Application for a non-material amendment following a grant of planning permission.
Town and Country Planning Act 1990

PORCH TO MAIN ENTRANCE

AB/44/13

TO REPLACE BRICK GABLE END TO GLASS GABLE END.

PROPOSED ELEVATIONS 1:100

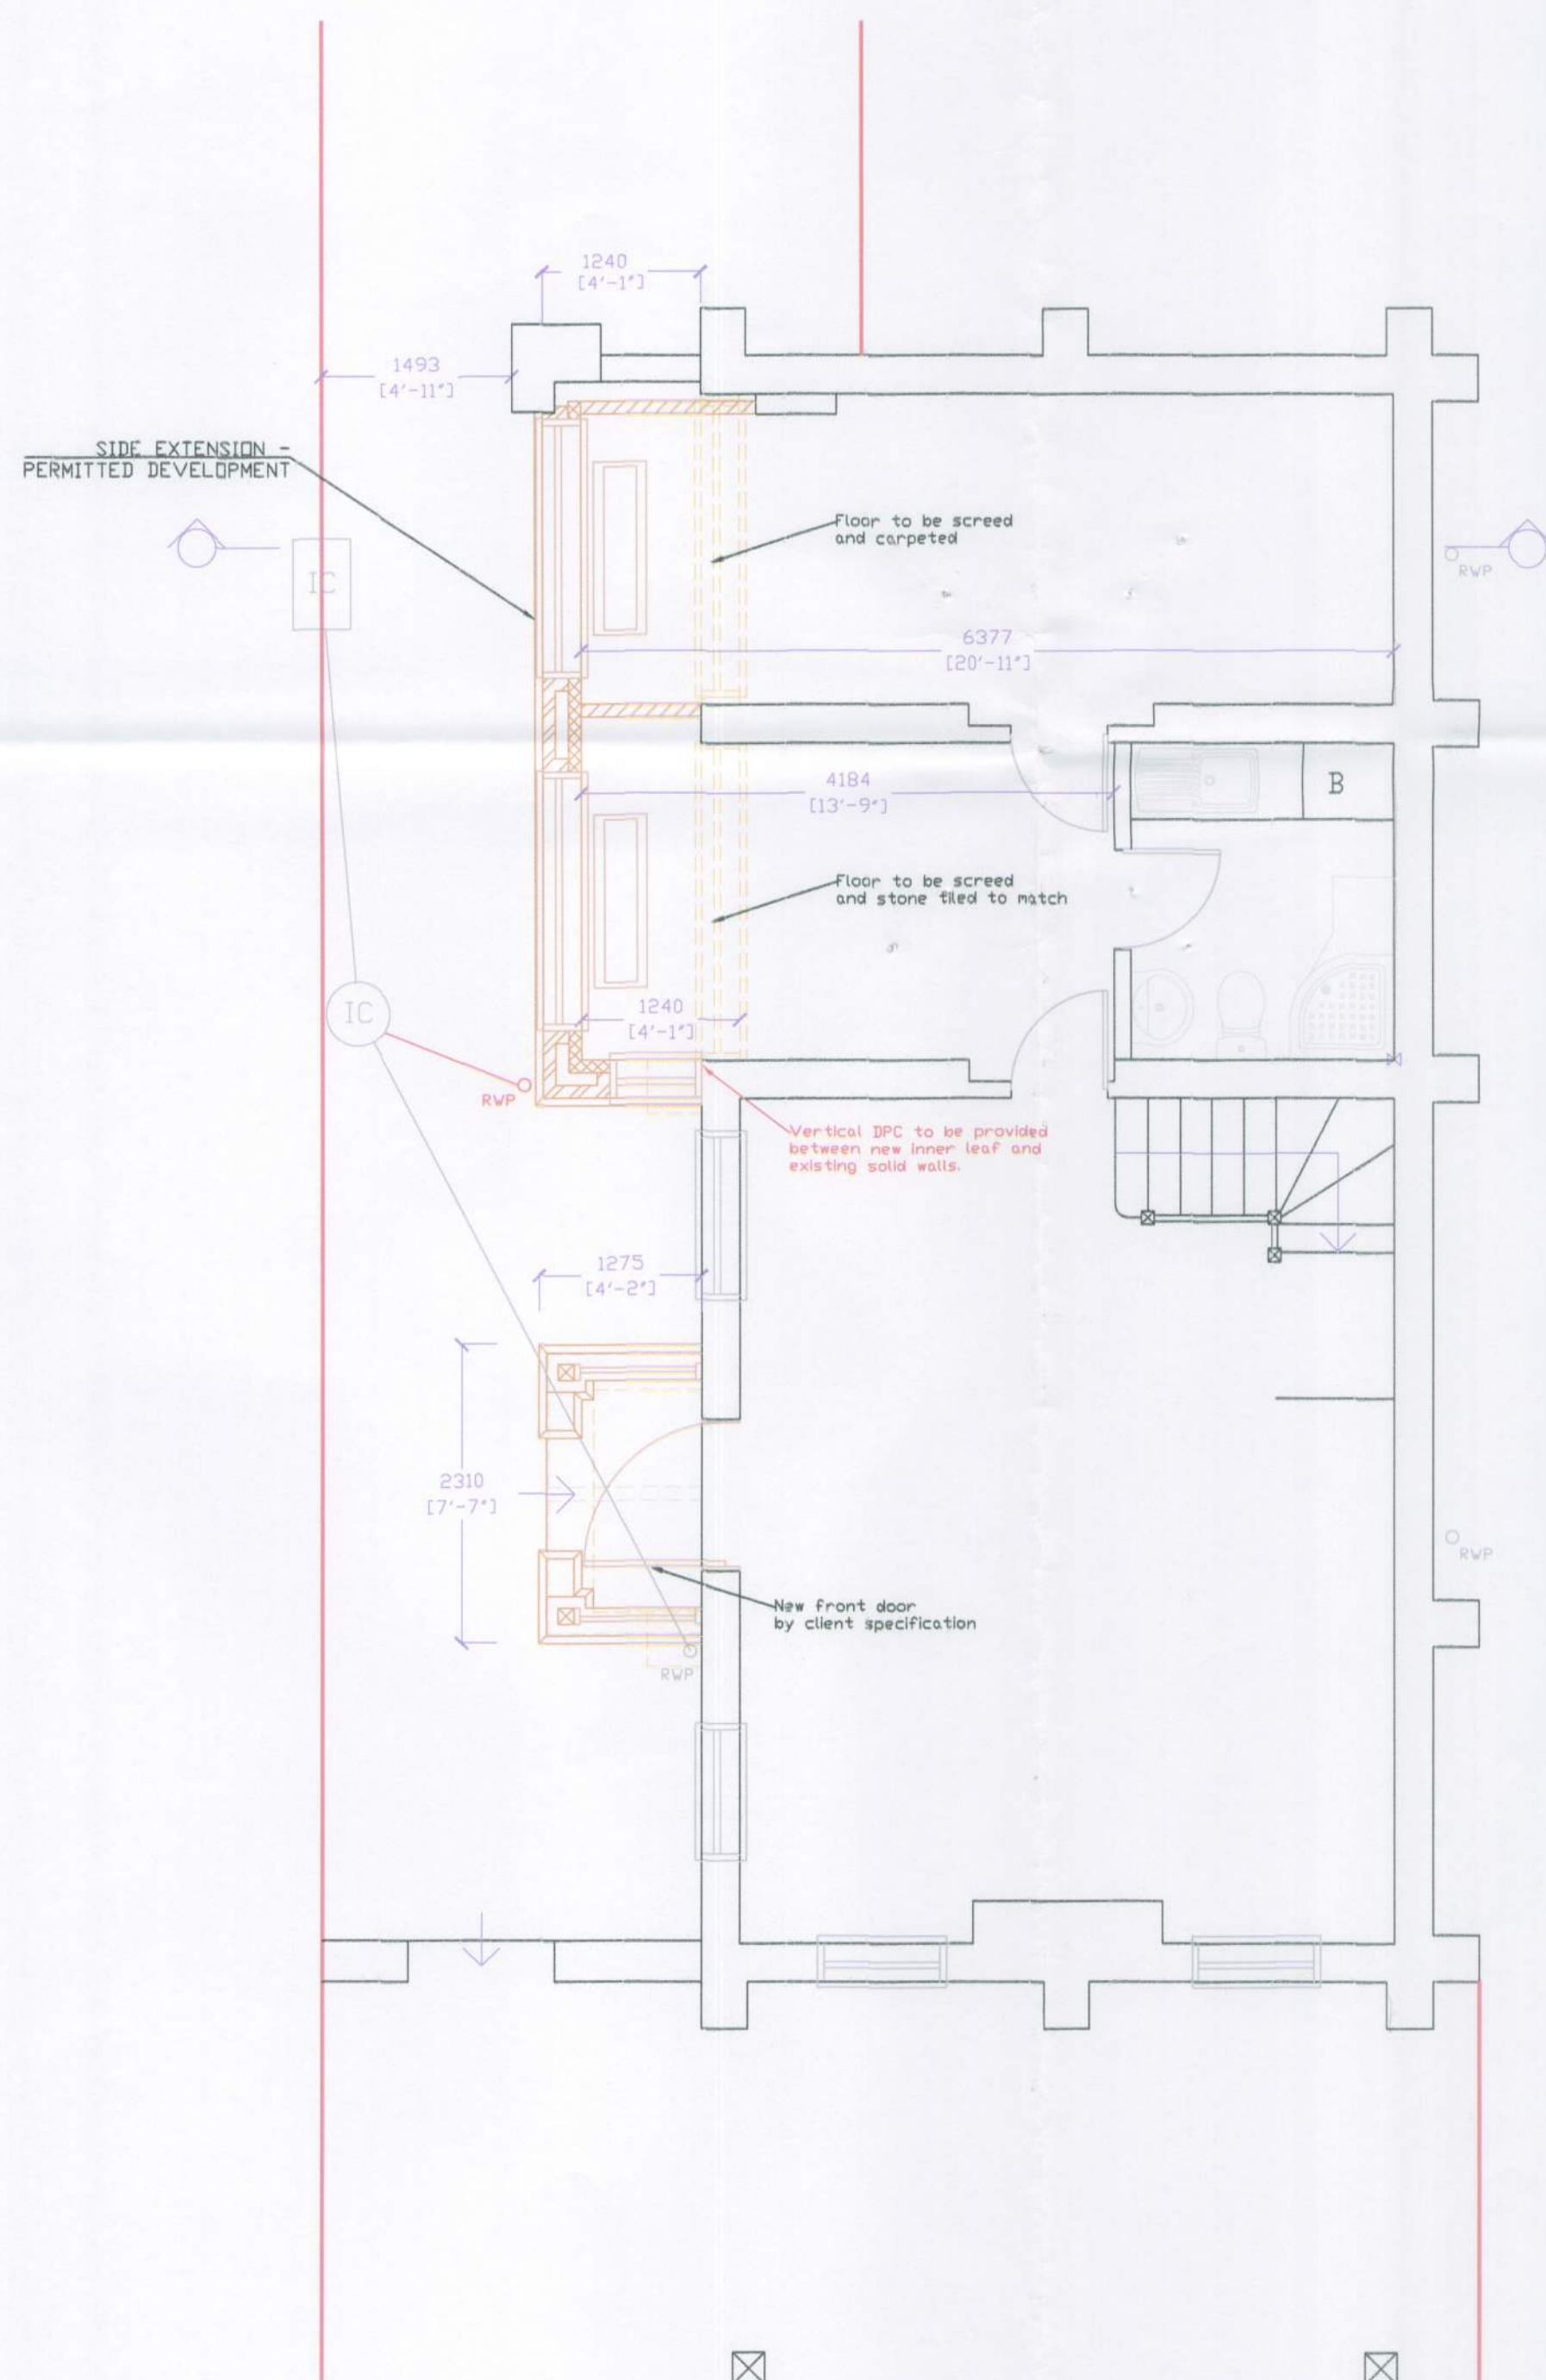
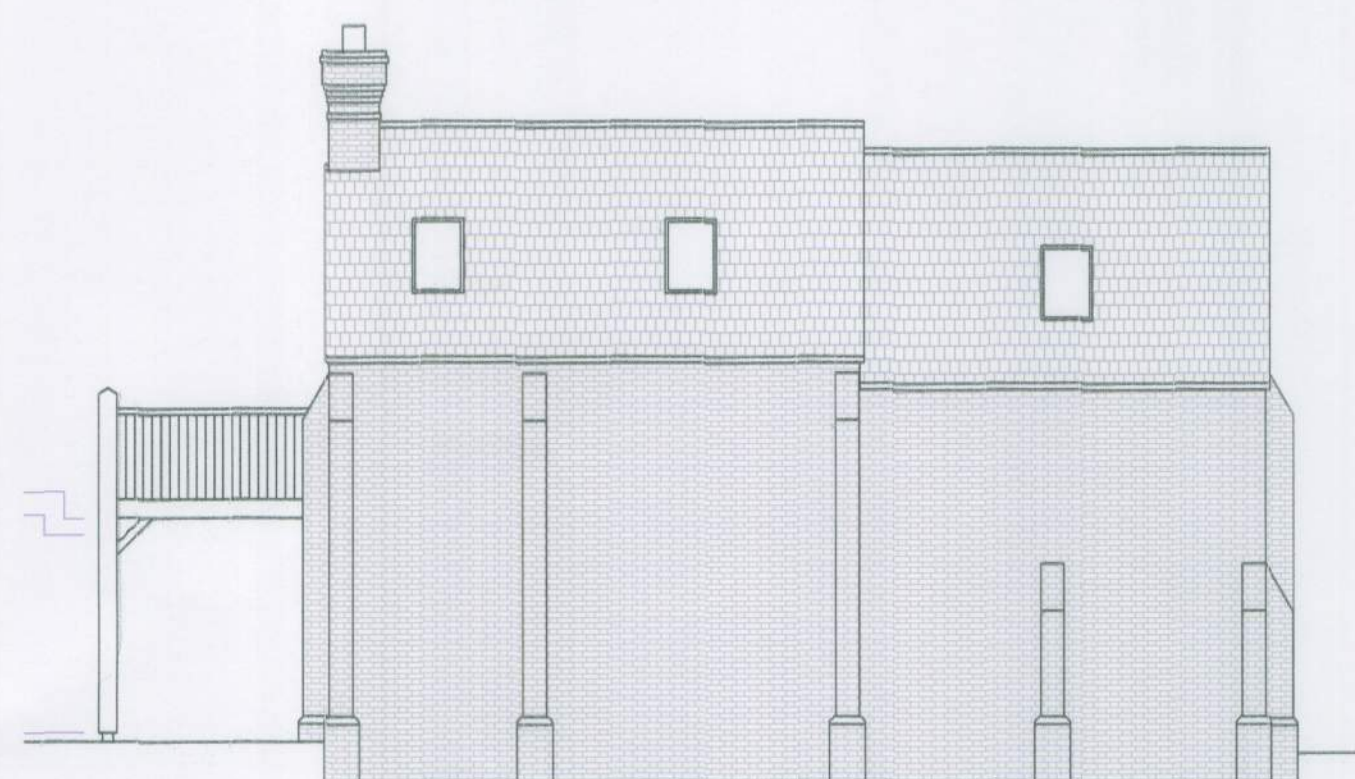
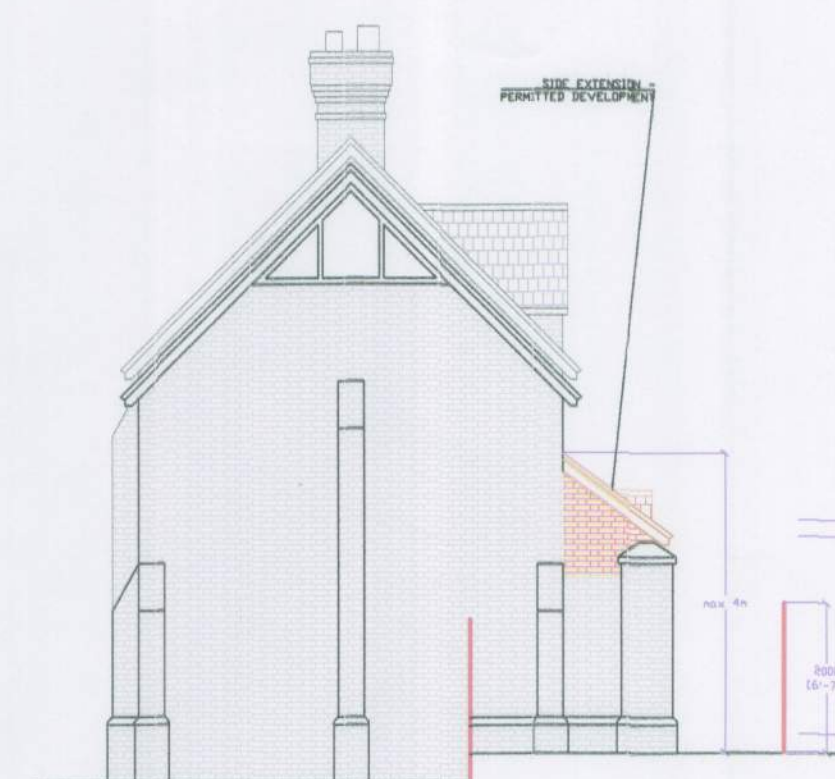
TO ALLOW MORE LIGHT INTO PORCH

12087/02R7.
